Online Comment

Application H02-0832-26
Location Land East of Normanton Road Crowland
Proposal Details of Construction Management Plan & Method Statement, Estate Road Phasing & Completion Plan and details of installation of fire hydrants (Conditions 14, 17 & 29 of H02-0759-25)

Name Crowland Parish Council
Address Parish Rooms Hall St. Crowland PE6 0EW

Date Submitted 23-09-26
For/Against Comments

DRAWING NO.
E0275-CMP-02

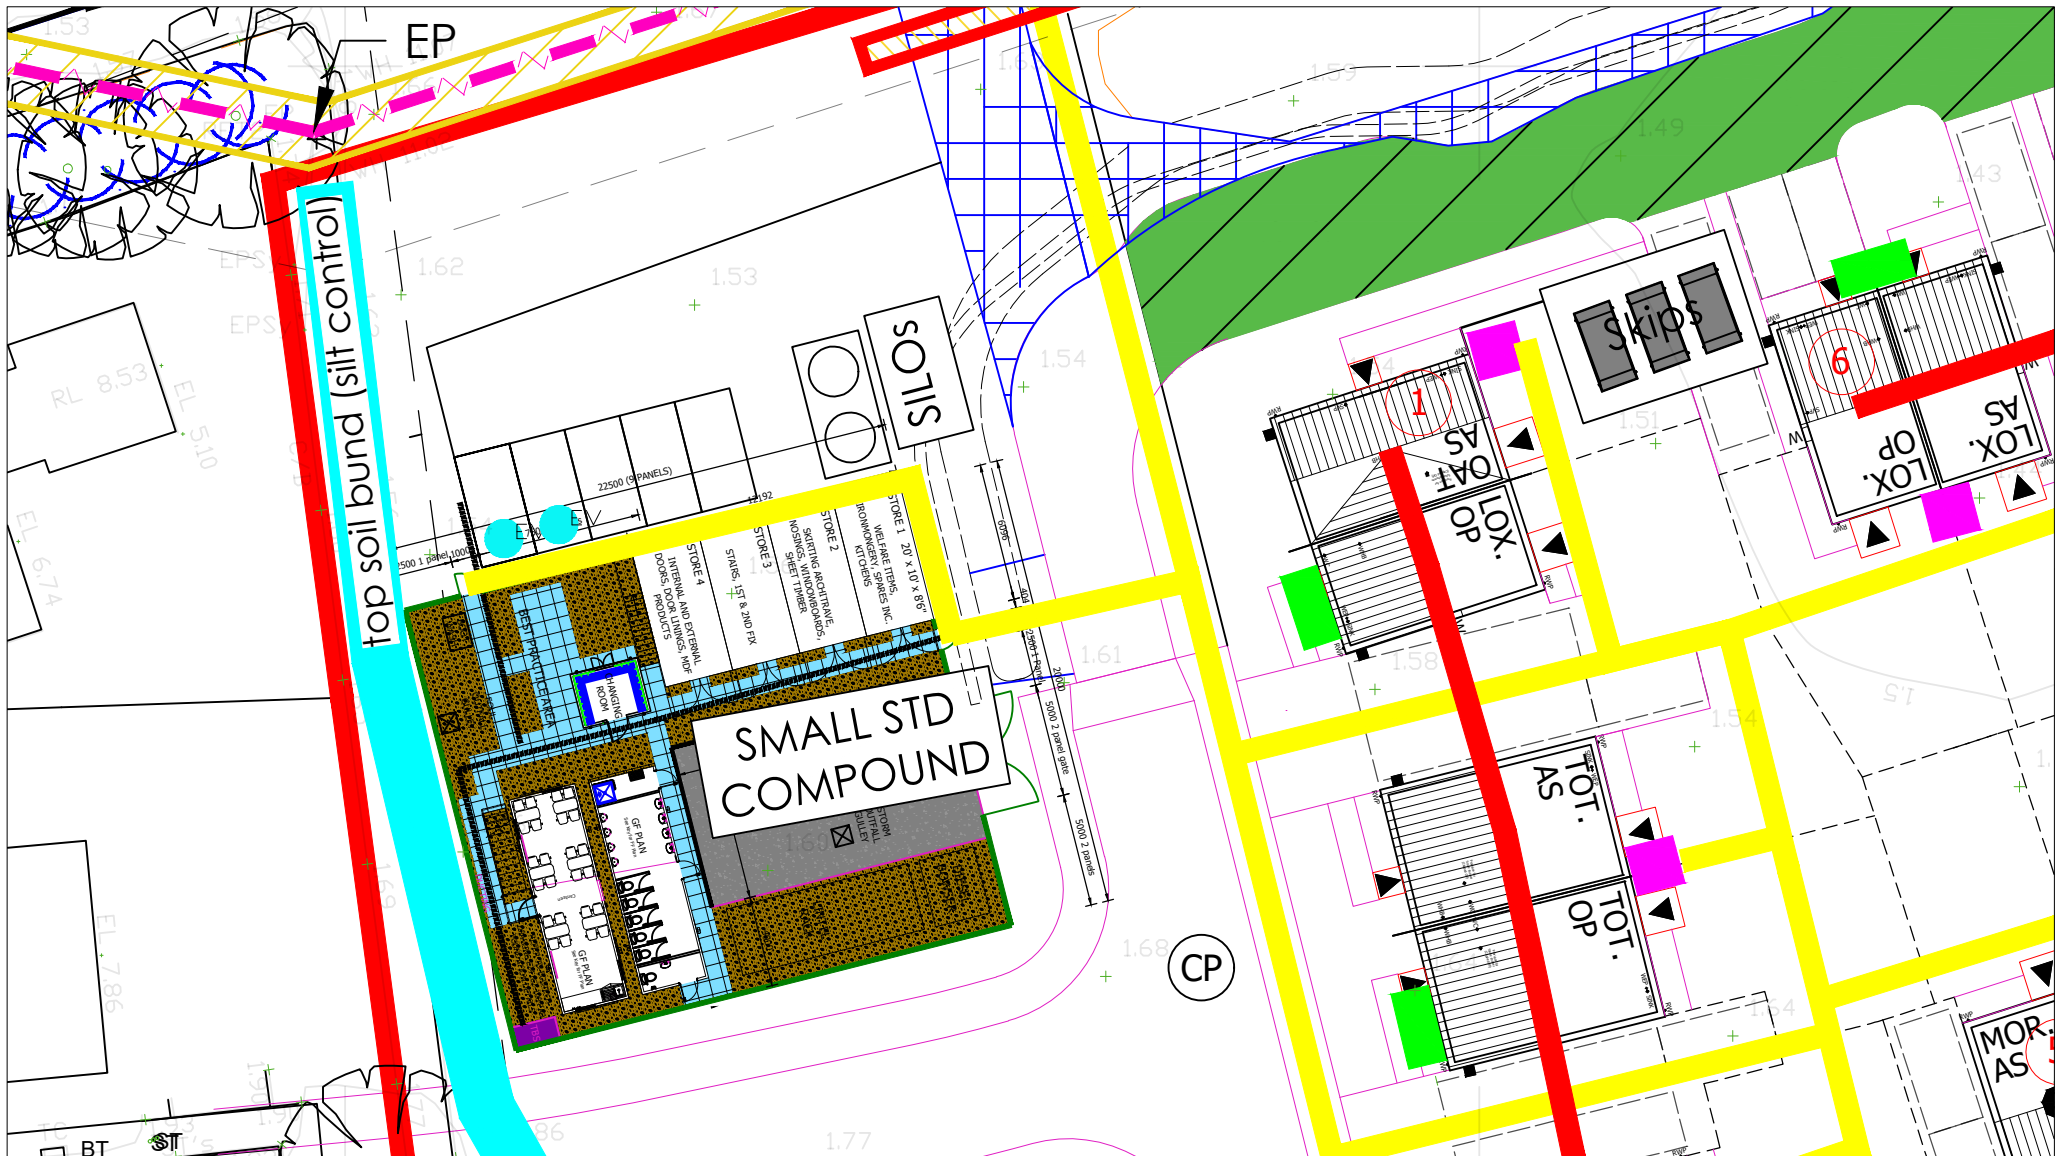
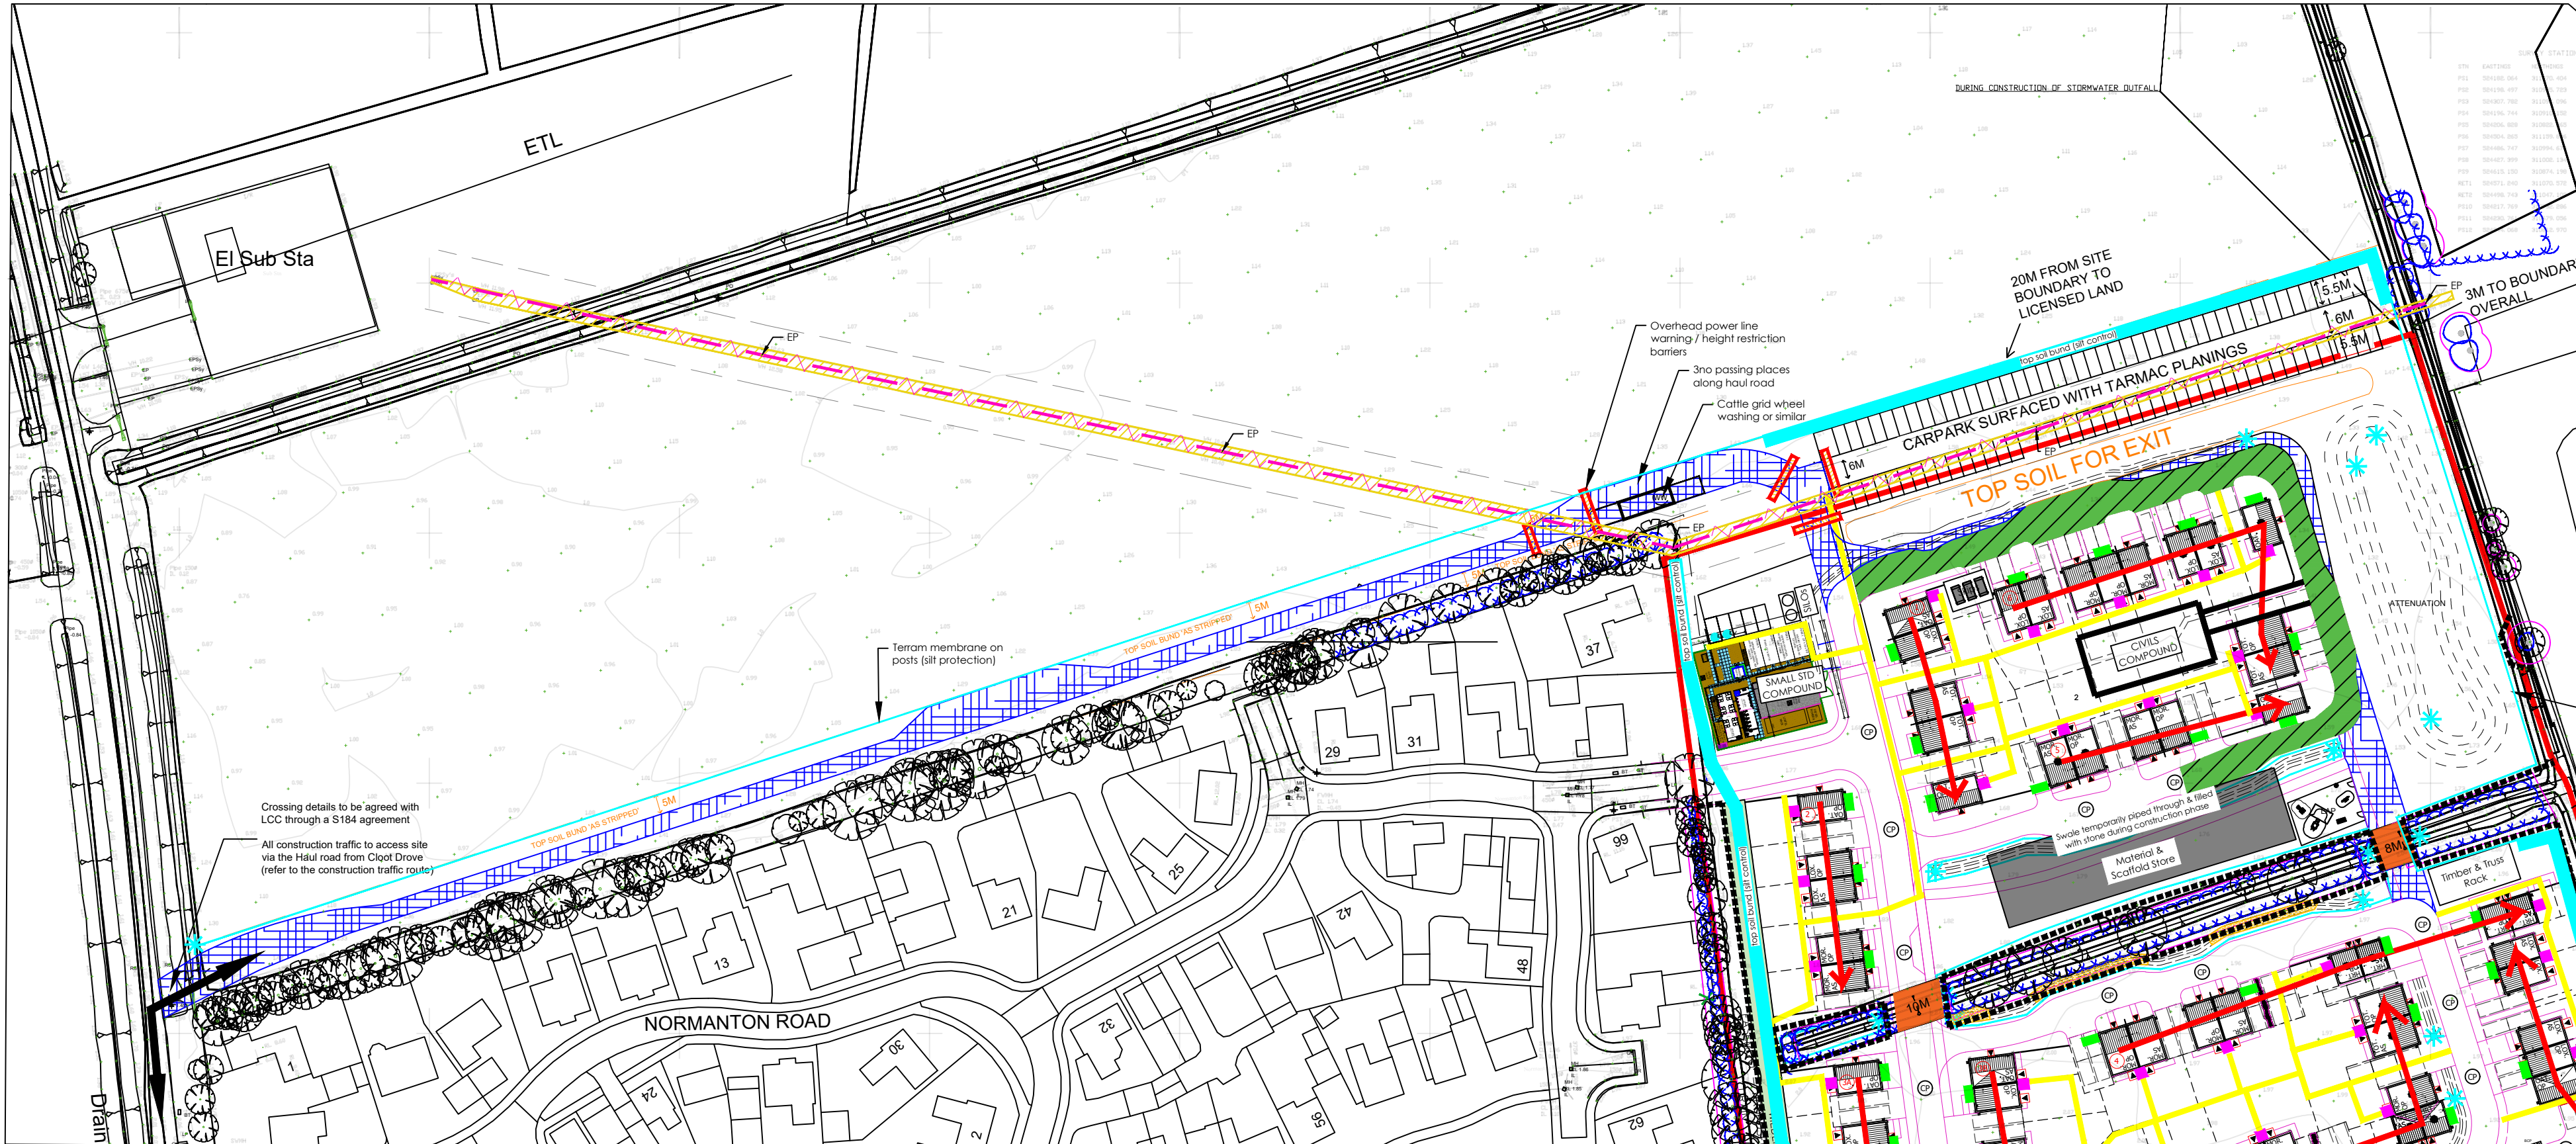
In particular, it does not appear that the proposed arrangements would prevent vehicles from accessing or using the existing development roads, nor is it clear what measures would be in place to control such use. This could potentially result in a significant increase in vehicle movements through the existing development and, consequently, create additional traffic and disturbance for existing residents.

We would therefore ask that the Planning Department carefully considers how vehicle movements will be controlled and whether adequate measures are in place to prevent an unacceptable increase in traffic affecting existing residents.
